To: Nick Hirst Investment & Regeneration Service Kirklees Council Civic Centre 1, Huddersfield, HD1 2EY	Ref: 2016/62/90049/W Date: 8 th March 2016
--	--

Turtle Bay, 50 King Street, Huddersfield

Erection of 2 'Jumbrellas' with weighted bases and integral heating and lighting, glazed screens with weighted bases and timber bench seating areas

Drp Name: **EXTERNAL BENCH SEATING**

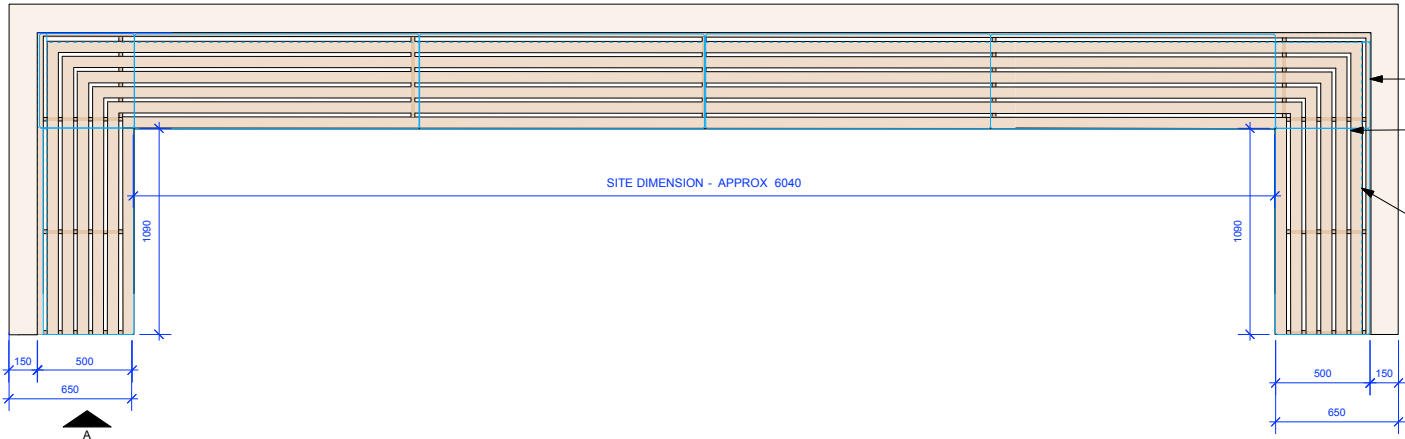
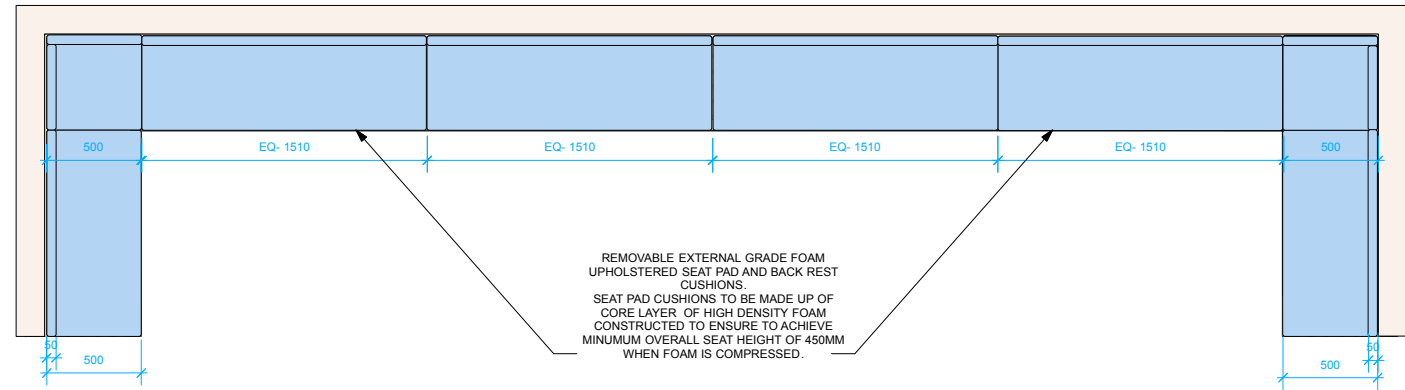
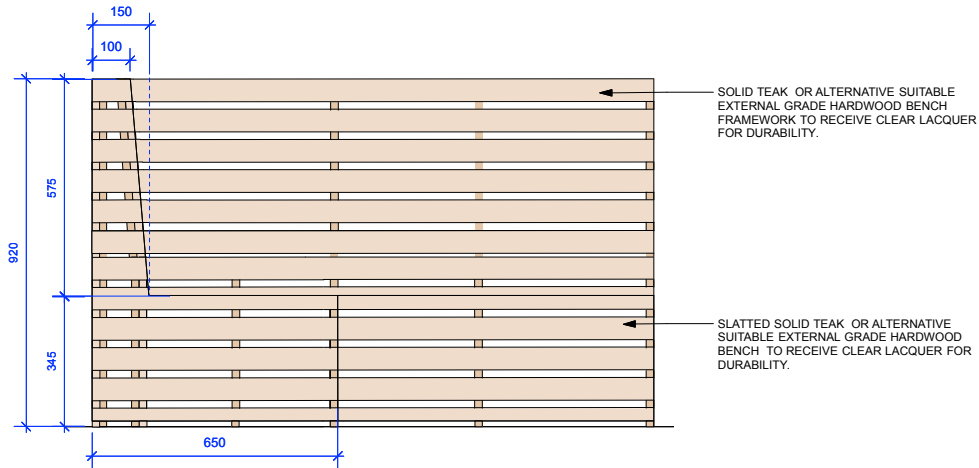
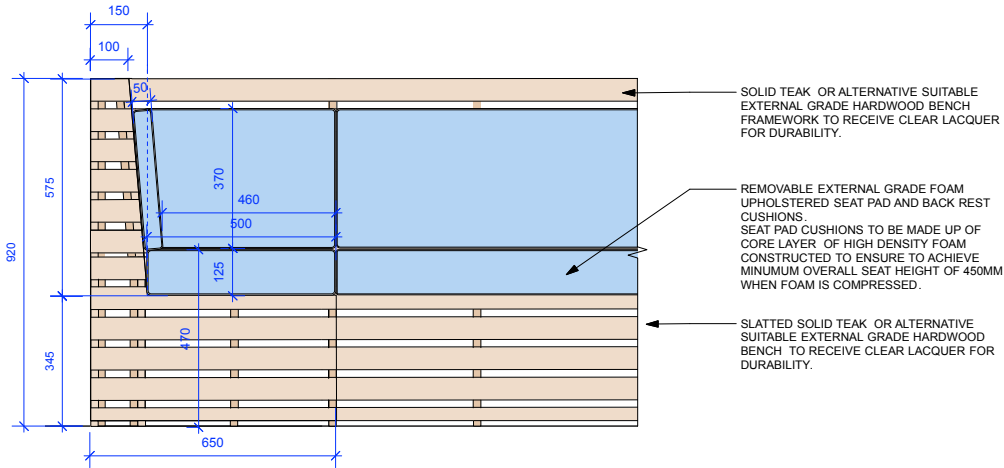
"All benches, loose seating, barriers and large umbrellas with heaters will not be fixed to the pavement"

If the equipment is not secured to the pavement:

Are the applicants intending putting the equipment out and removing it again every day?

The equipment will need to be removed from the street and put away on a daily basis. If it is left insecurely, the equipment would be likely to be tampered with, moved or thrown about, damaged, and used for various unauthorised activity.

There needs to be a commitment from the applicants to remove the equipment from the street daily.
